**Ann Machado - Concerns relating to Verizon's October 20, 2015, Conditional Use Appeal Application for 1877 Congress Street, Portland**

I am an abutter to 1877 Congress Street, Portland, Maine. I live at 66 River's Edge Drive (Lot 9) in the Stroudwater Farm subdivision. I have the following concerns relating to Verizon's Conditional Use Appeal application dated October 20, 2015.

SHEET TITLE	
DETAILED SITE PLAN	
SHEET NUMBER

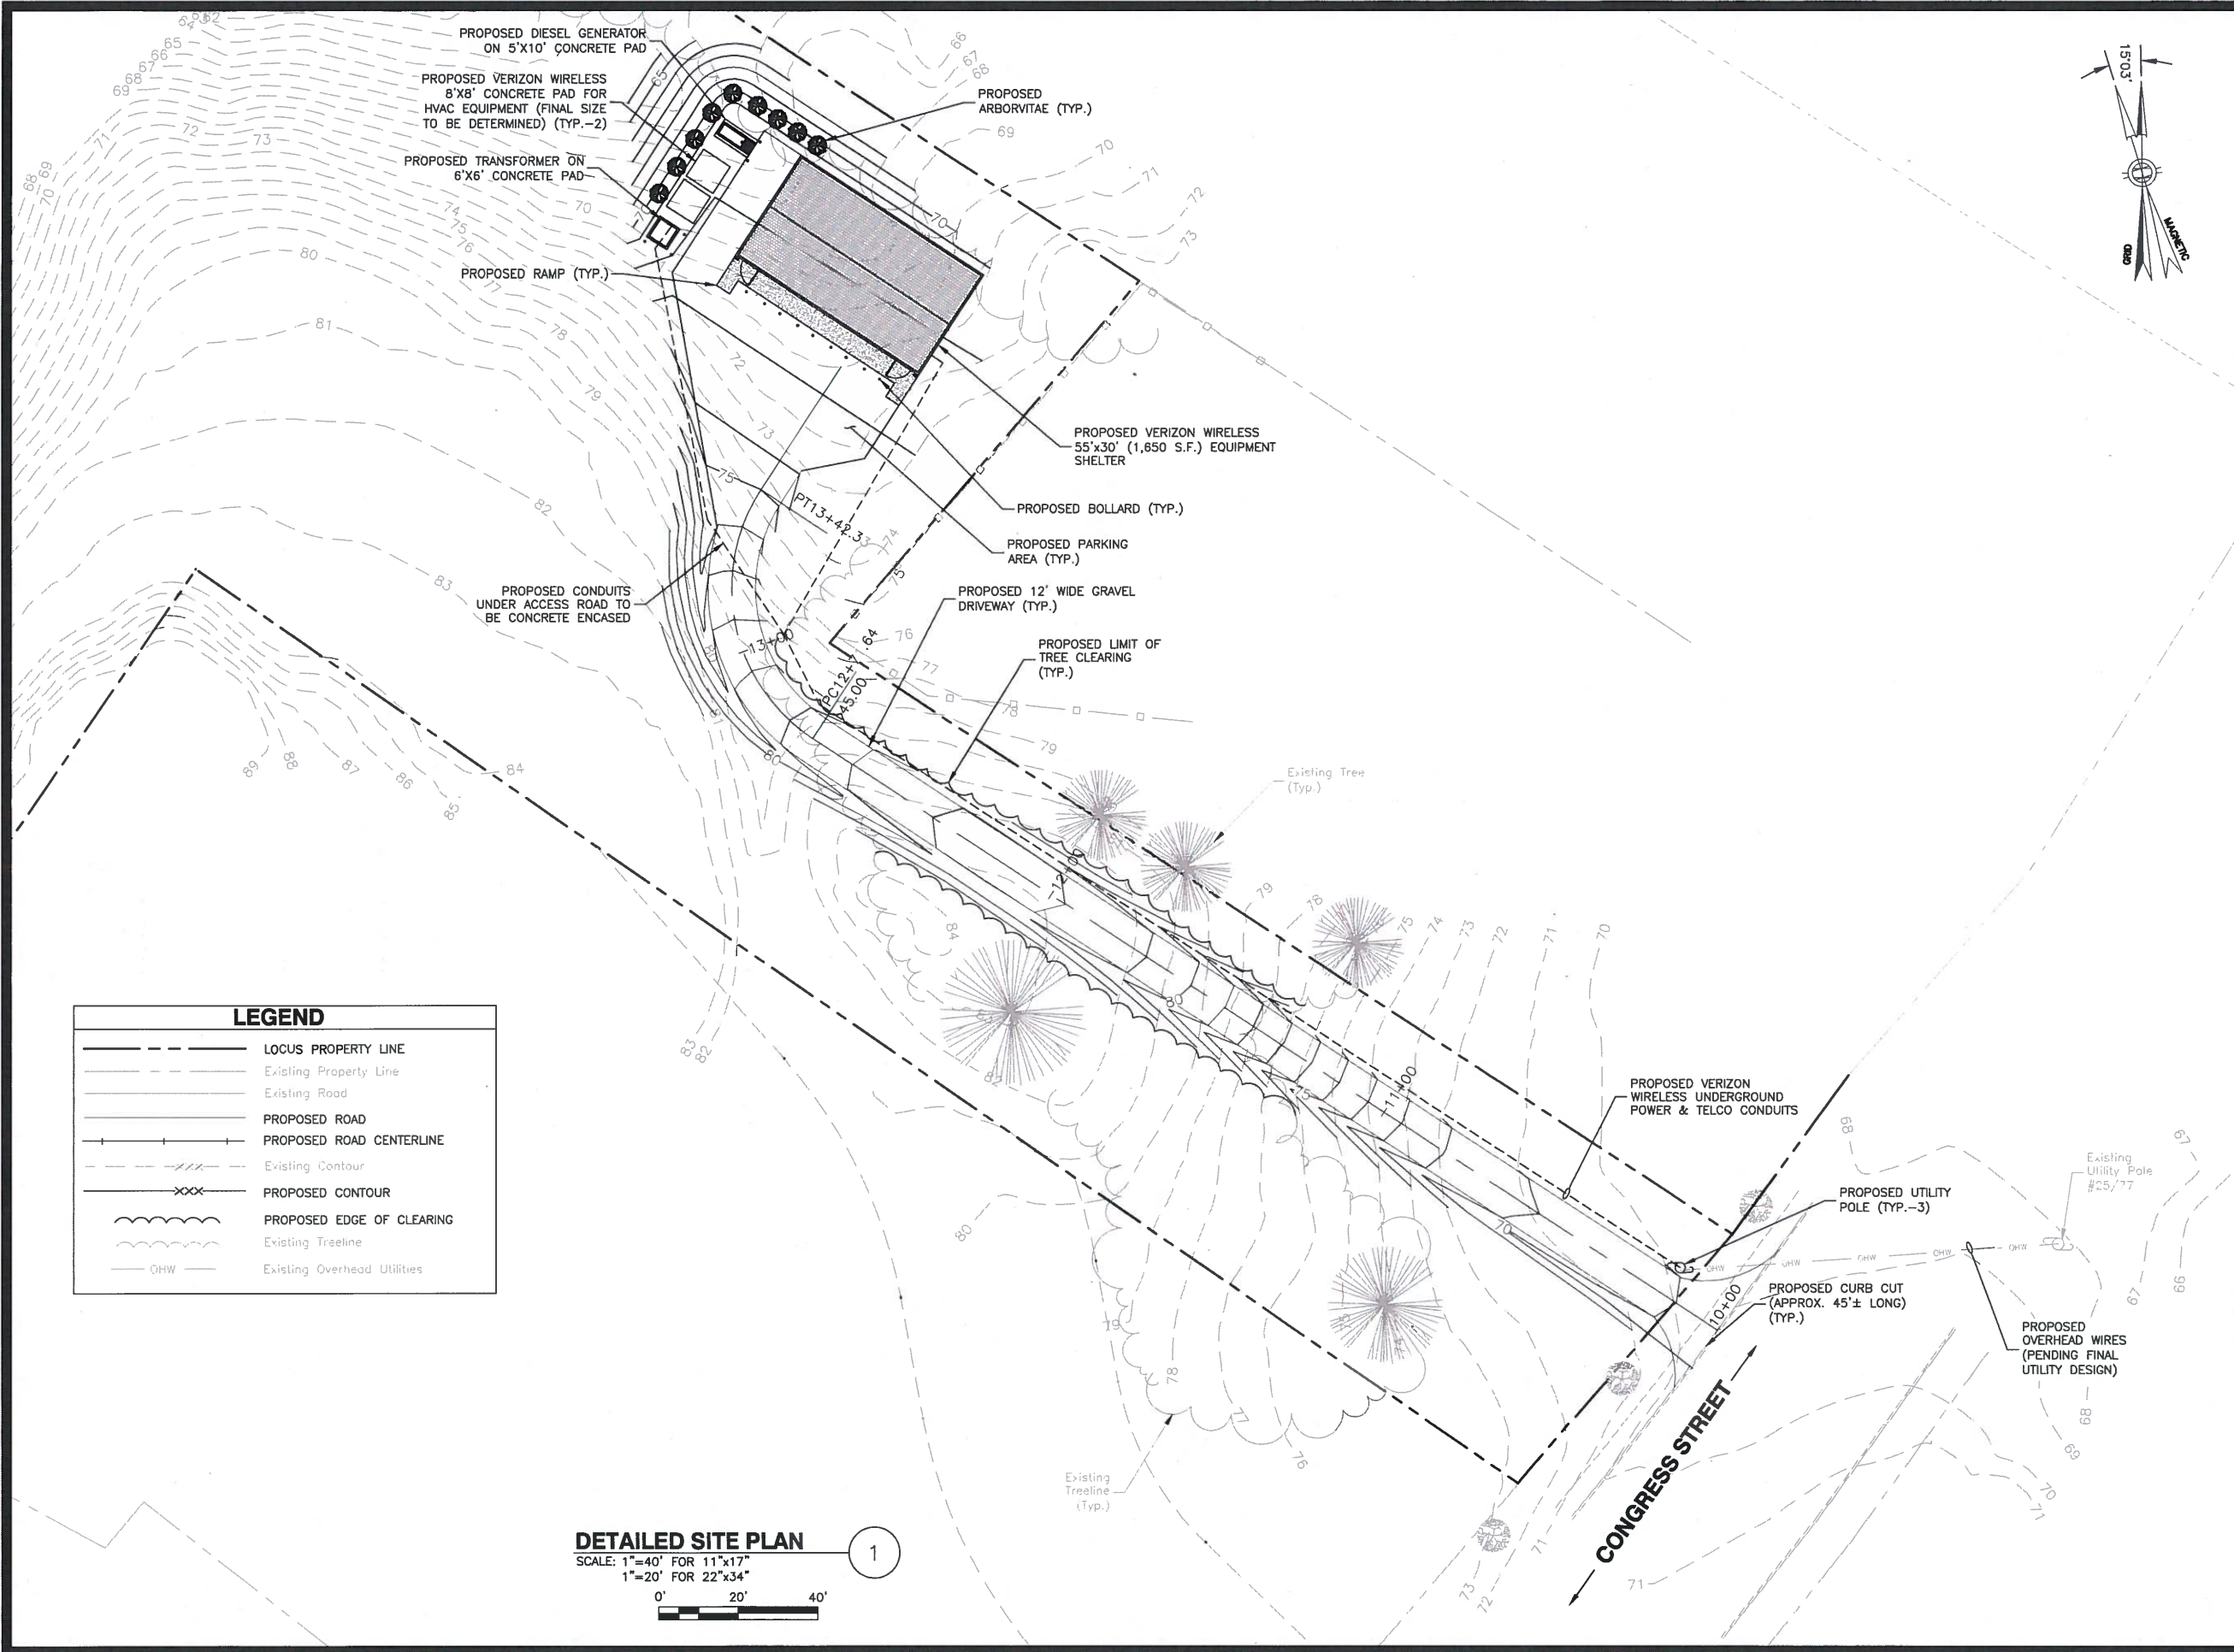
As planned, the center of the grade for the Facility would be 71' above grade. Adding the building's 18' elevation, depicts the center of the Facility would rise about 89' above sea level.

I would think Verizon would want to be a good neighbor and keep the generator away from its immediate neighbors. This plan fails that.

**4) Verizon wants to acquire 4 acres yet seeks to shoehorn the Facility in one small corner of the property closest to its Stroudwater Farm neighbors and another Congress Street abutter.**

ELEVATIONS

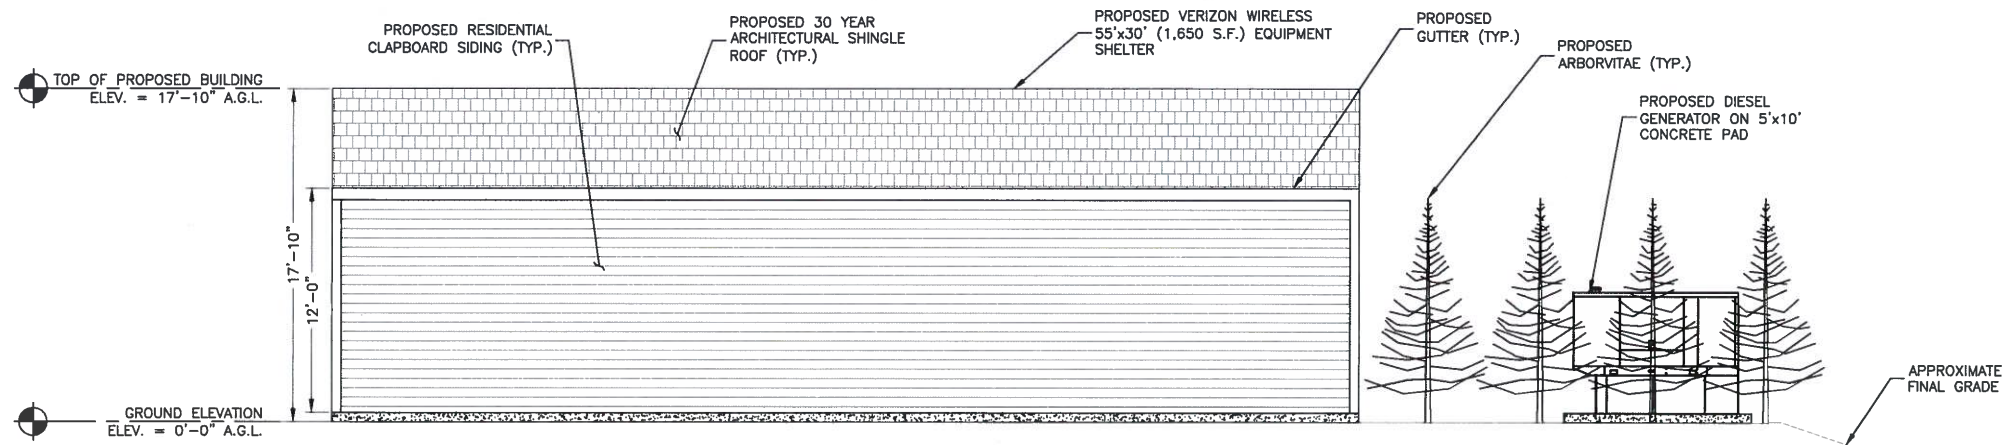
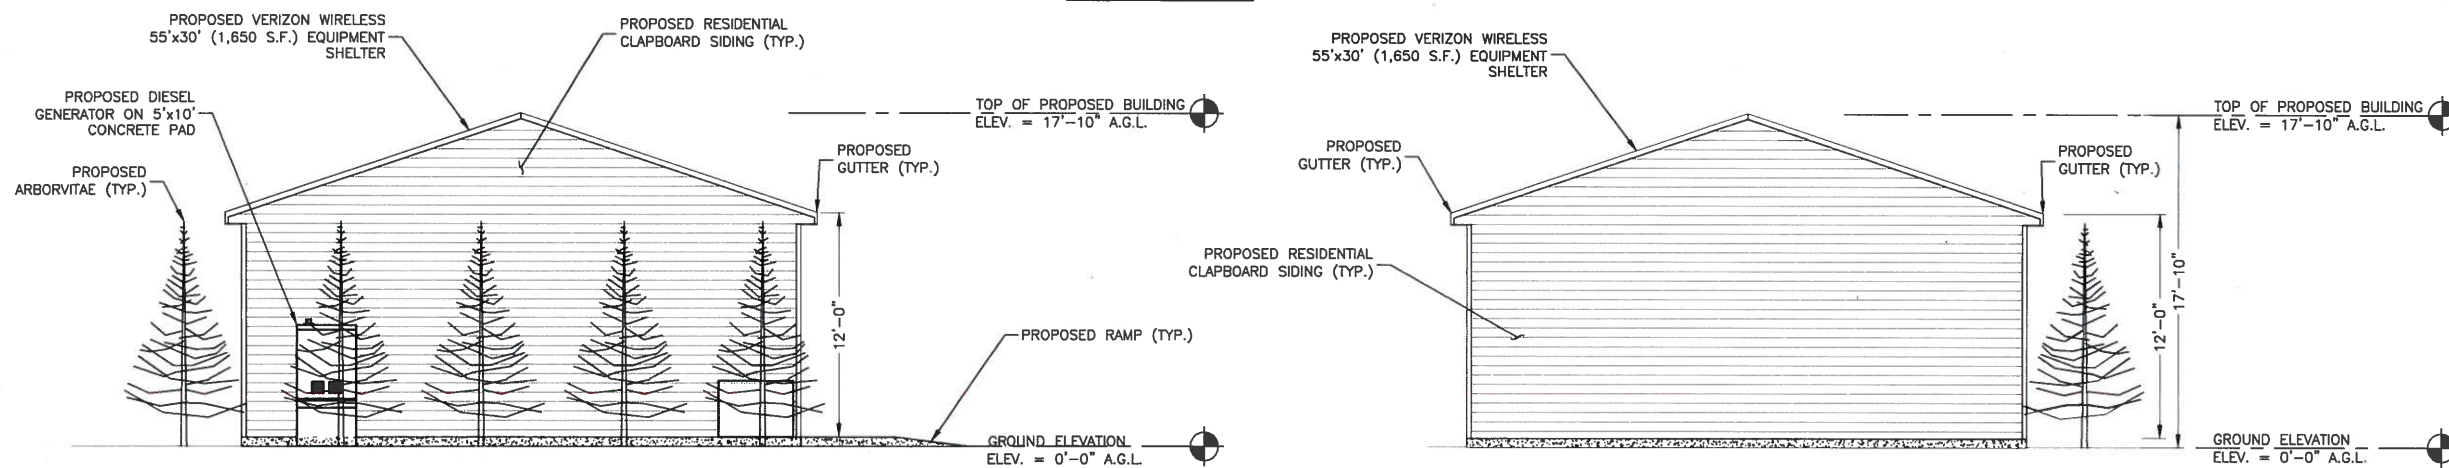
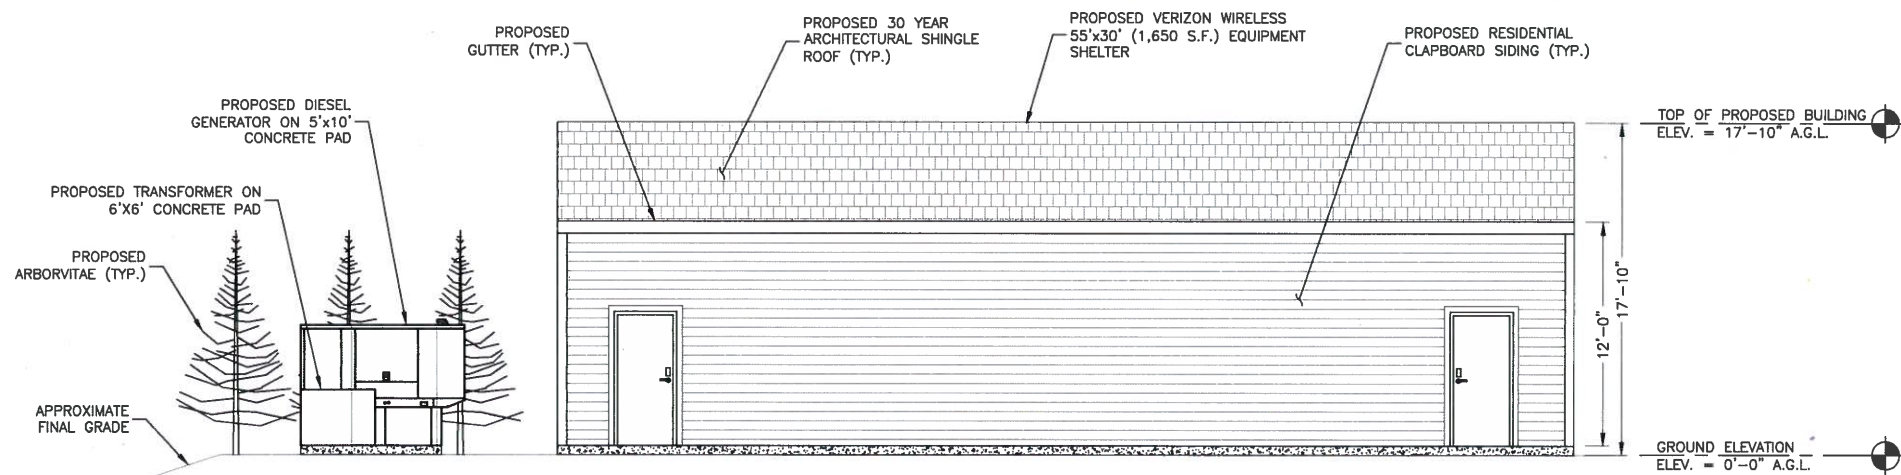
The Facility plans show a final elevation just below 18' above grade.

Lots 6 and 7 are most adversely affected given their close proximity. Is it necessary for the building to be so tall? Could the building be partially constructed below grade to lessen its height and thereby better "fit in to the surrounding neighborhood" as quoted from the application?

Rather than fitting in, it would dominate the site. Its flora is slow growing and nowhere near 18' in height in unison. The statement, "fit in to the existing landscape of the site", is a non-sequitur.

The elevations should clearly state the clapboard siding would be vinyl.

Why are gutters needed? Properly insulated buildings don't need gutters. Storm water can easily be collected below grade with perimeter drainage and directed a designated area. Further, gutters require constant maintenance.

The present design of the Facility is not inspiring. The planned vinyl sided warehouse offers NO architectural appeal in one of Portland's oldest neighborhoods. Instead of the monolithic plastic building with no break (windows) in its design, perhaps a clapboard (or shingle) building shaped and
